ENG-CDR23021-R2-CDs-S1.pdf Markup Summary

Subject: SW - Textbox with Arrow
Page Index: 1
Date: 4/2/2024 3:34:42 PM
Author: Glenn Reese - EPC Stormwater
Color: ■
Layer:
Space:
Page Label: [1] 1 COVER

FROM GRANDVIEW FILING 1 TO REX RD (SEGMENT 2)
 STORM PLAN & PROFILE II

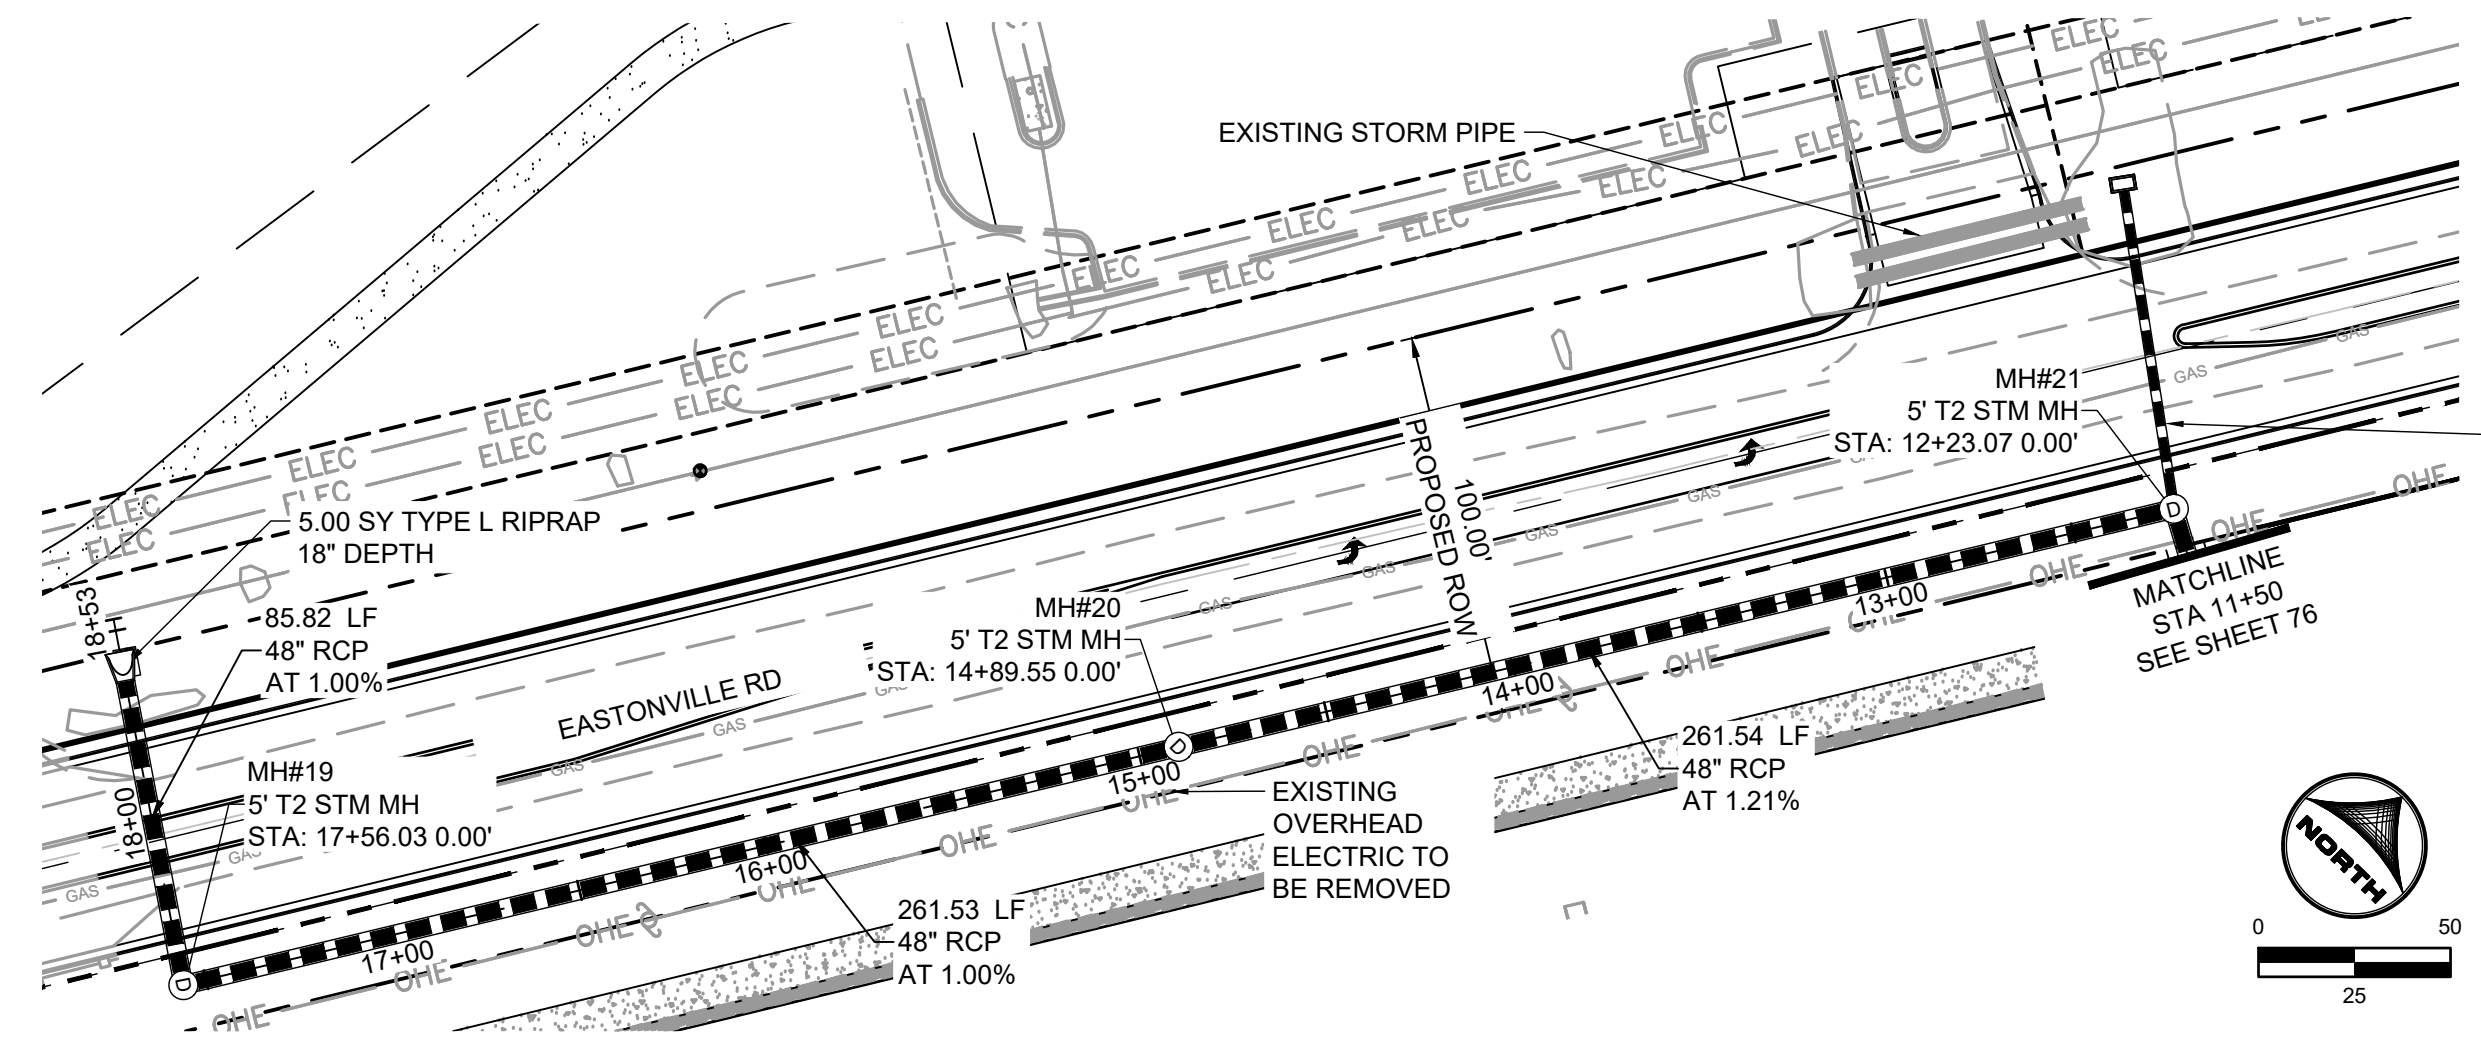
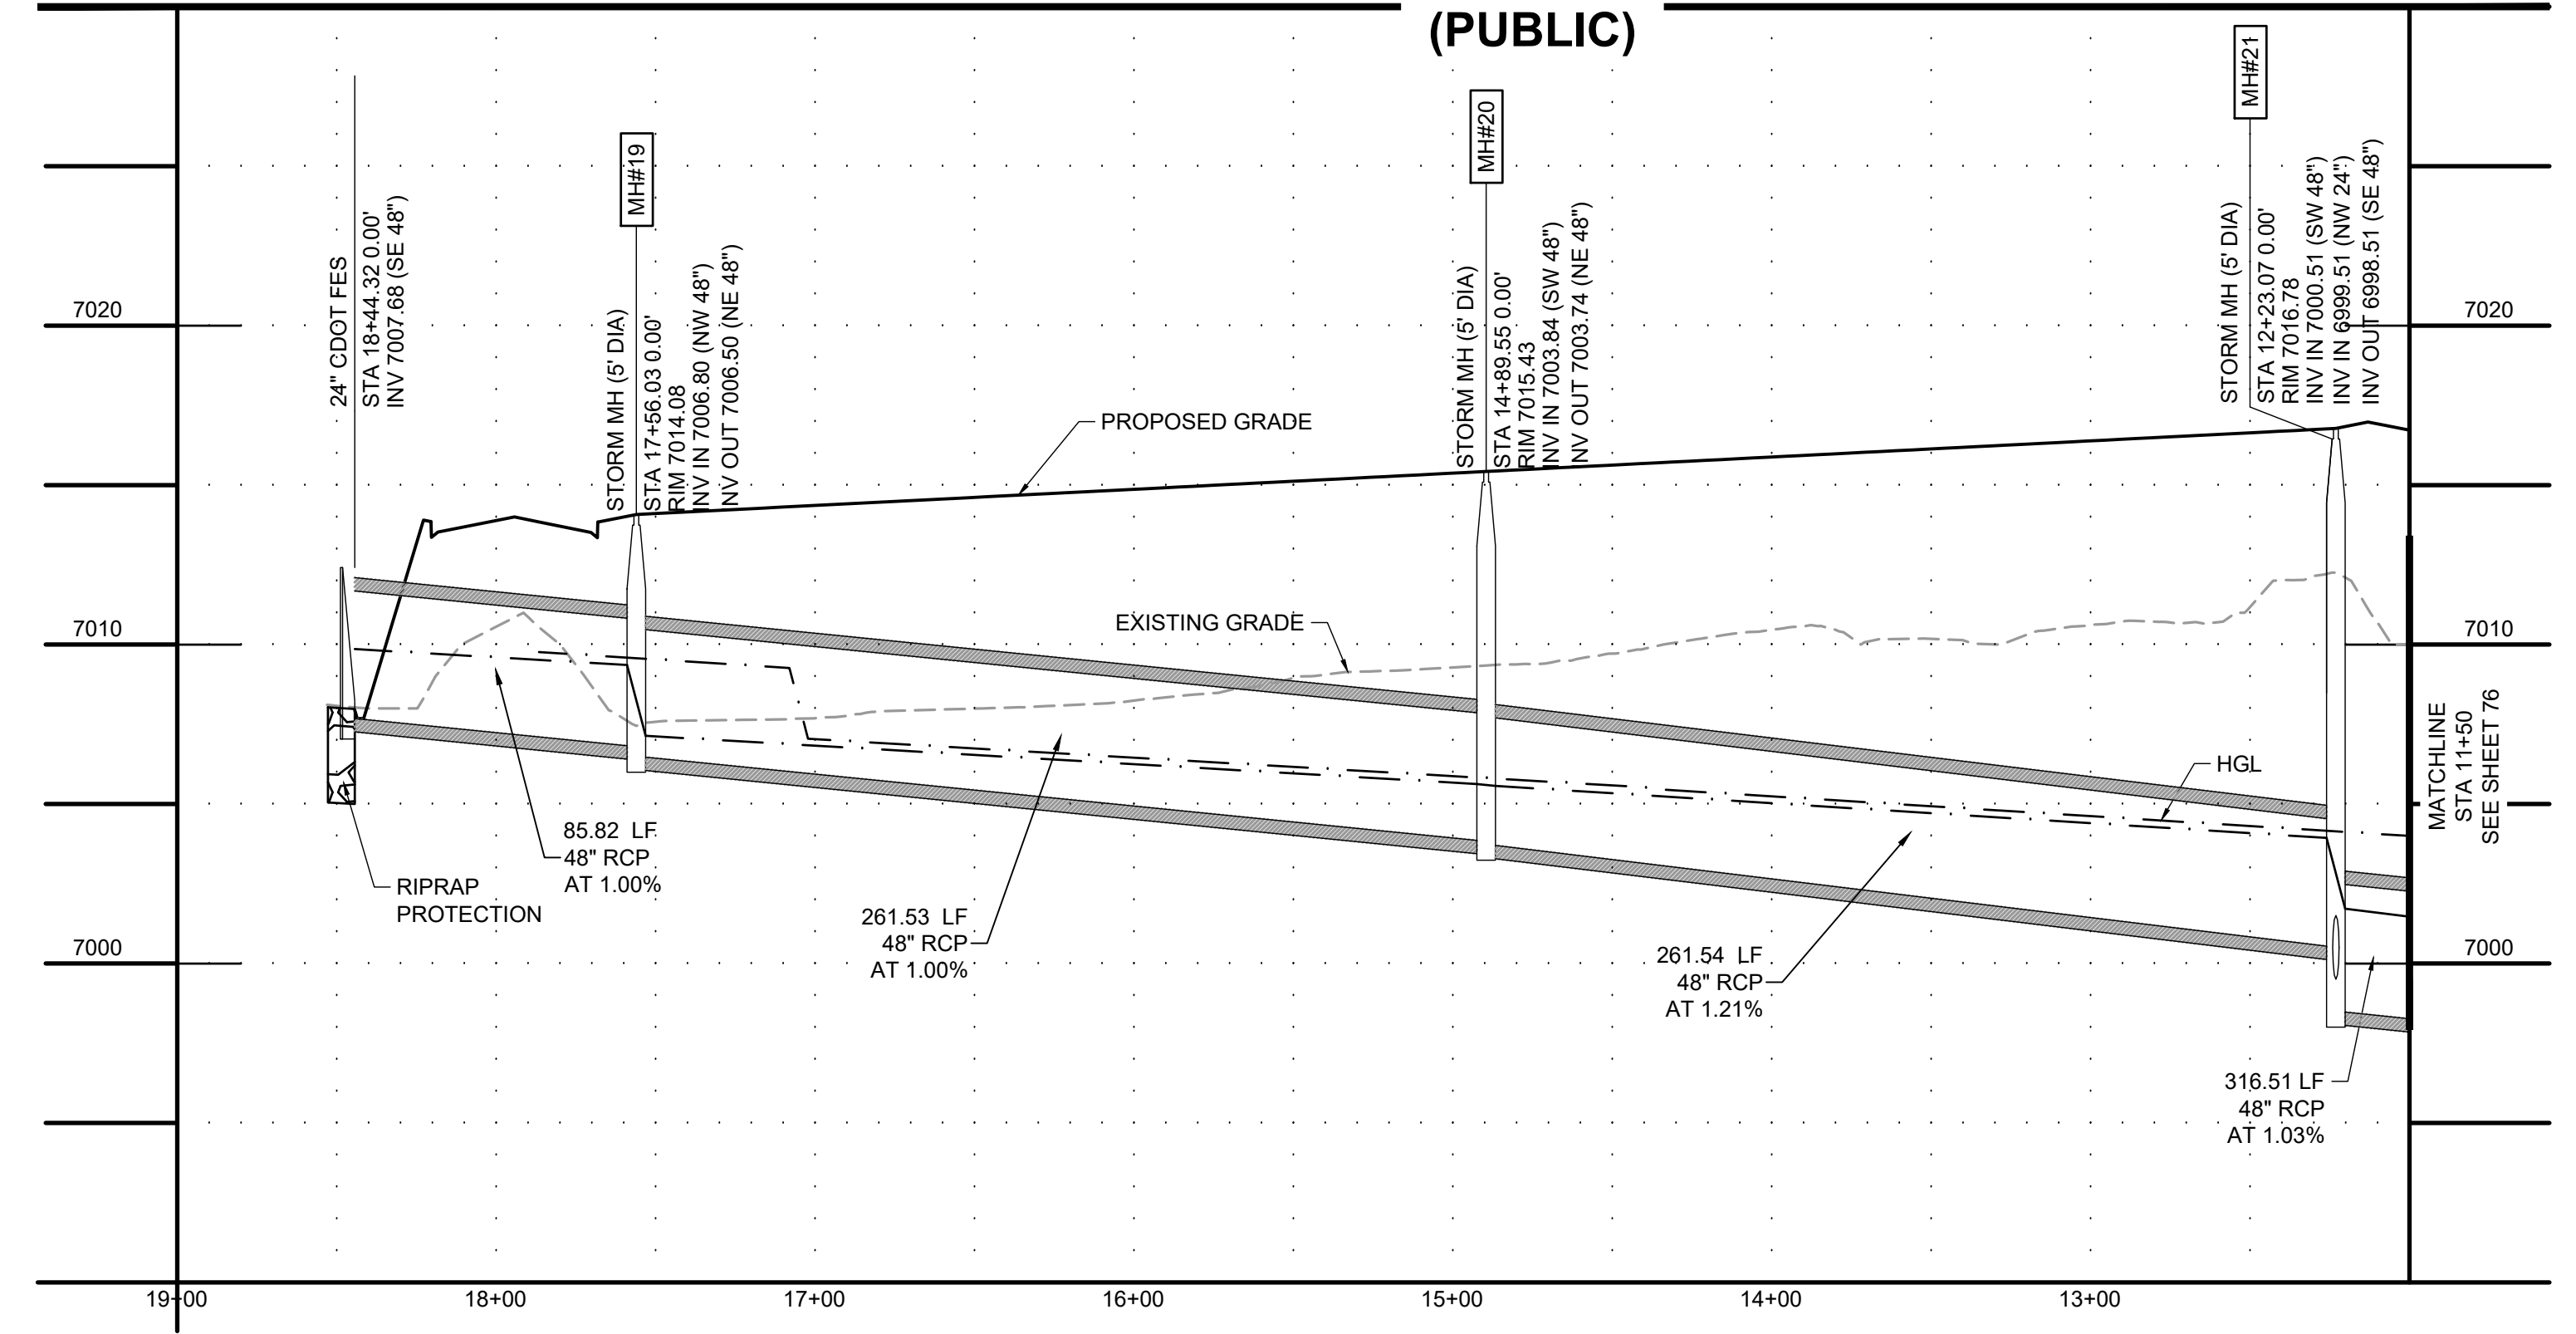
Pipe should not be below grade. Show riprap outlet protection. Provide invert elevation

Slope should not be negative. Please revise

Pipe should reach to proposed grade. Show beginning of forebay. Provide invert elevation

Label manholes

Label all storm infrastructure as public or private (All storm sheets)

Highlighted items do not match with StormCAD information in FDR. Please revise so plans and documents match. (Typical all storm sheets)

Provide detail or additional design information in notes for outlet protection (all storm sheets)

5-yr HGL's need to be shown wherever pipes are surcharged for 100-yr design

For all outlet locations:
 Outfall labeled: end section and headwalls labeled, riprap apron (length, depth, type, D50), toe wall shown, profile of existing ground shown for 200 feet downstream of outfall, Q100 water surface elevation downstream of outfall
